Subject: Re: 2025/93480 - Land off Parkwood Road/Weavers Lane, Longwood, Huddersfield, HD3 4TT

Further Representation – Plot 26 and Plot 27 and suggestion for consideration

SECTION AA (PLOTS 26, 27 & 28)

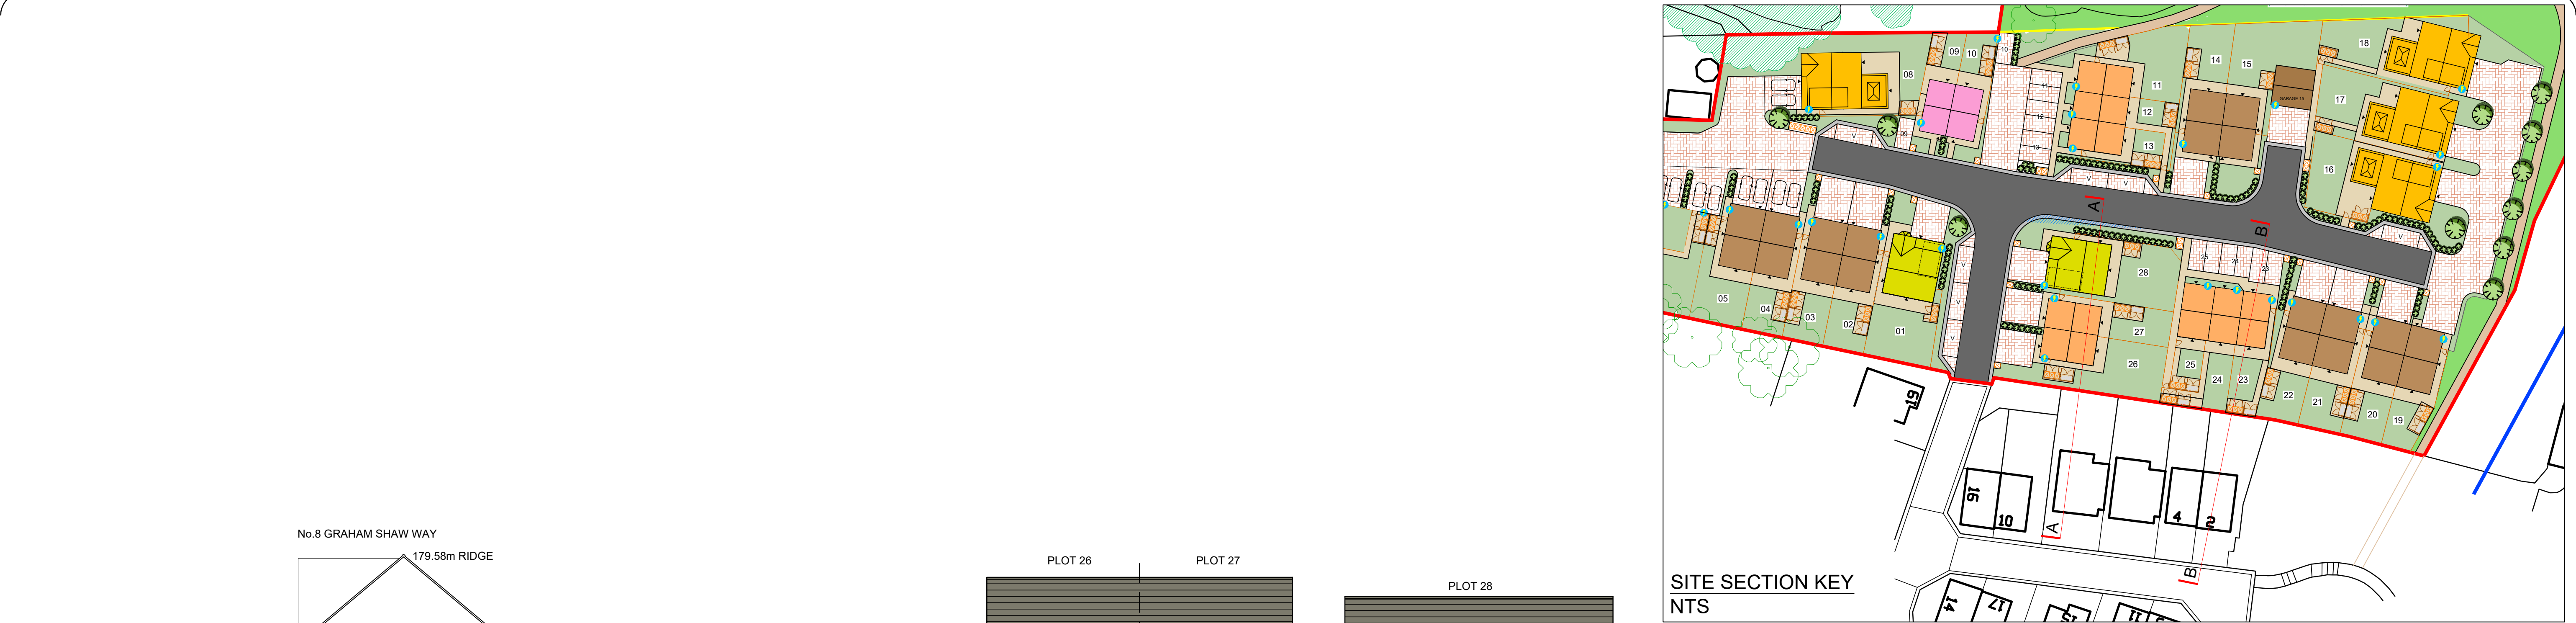
The submitted section drawings demonstrate that Plot 26 would sit approximately 13.67 metres from the eaves of my property at No. 8 and approximately 15.34 metres from ridge to ridge. While I appreciate that these measurements may comply with minimum standards, the plans clearly demonstrate that the impact upon my property is substantially greater than that experienced by any other neighbouring dwelling both in height and proximity.

Plot 26 does not appear to follow the established building line of either the existing dwellings or the majority of the proposed development. Instead, it projects significantly towards my property, resulting in a relationship that is fundamentally different from that experienced elsewhere within the scheme.

Can the applicant explain why Plot 26 cannot be repositioned to align with Plot 28 and the remaining proposed dwellings, and whether alternative layouts have been considered?" Why does this particular house need to be in this position, which deviates from the building line, as if it has been squeezed in purely for commercial purposes?

The consequence is that the full two-storey gable and rear elevation of Plot 26 would present an overbearing and intrusive presence immediately adjacent to my home and garden. This creates a sense of enclosure, dominance and loss of amenity that extends well beyond the simple measurement of separation distances.

The submitted drawings demonstrate that this harm is not inevitable. If Plot 26, and potentially Plot 27, were repositioned so that they followed a more consistent building line with the remainder of the development, the disproportionate impact upon my

property could be significantly reduced whilst still allowing the development to proceed and deliver the proposed housing. A further alternative would be to change the 2 dwellings to 1 property , allowing for repositioning to create space and reduce overall impact, whilst remaining in keeping with the development and bedrooms available to future residents.

SECTION BB (PLOTS 23)

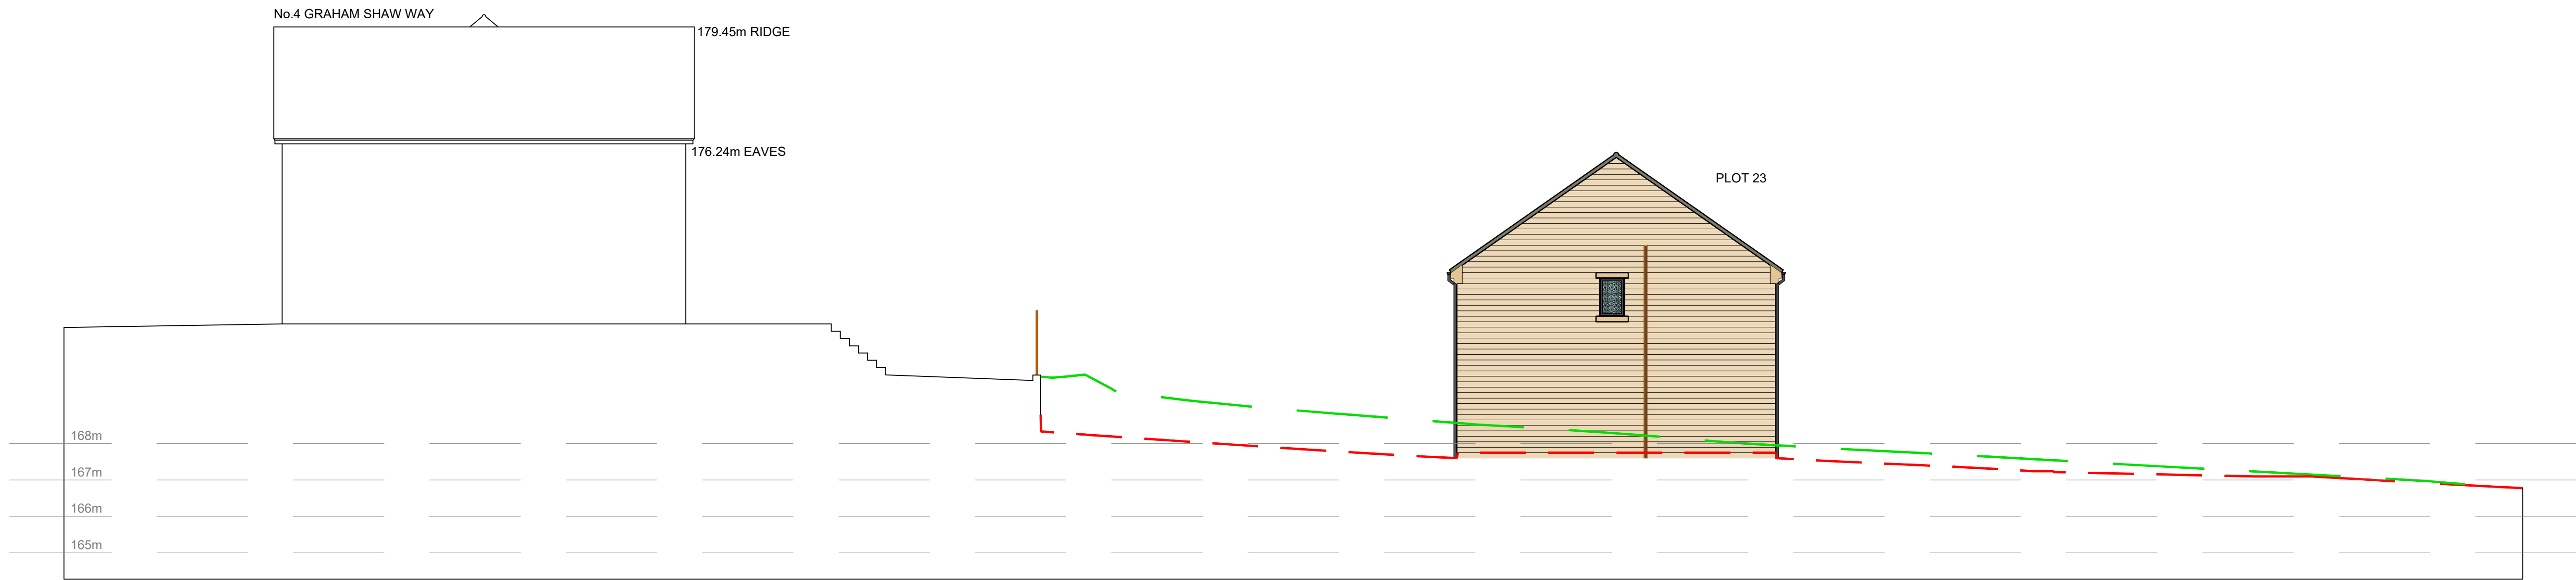
The planning assessment elsewhere within the application appears to recognise the importance of relationships between proposed and existing dwellings, including the relationship between Plot 23 and neighbouring properties. I respectfully ask that the same principles be applied consistently to the relationship between Plot 26 and No.8.
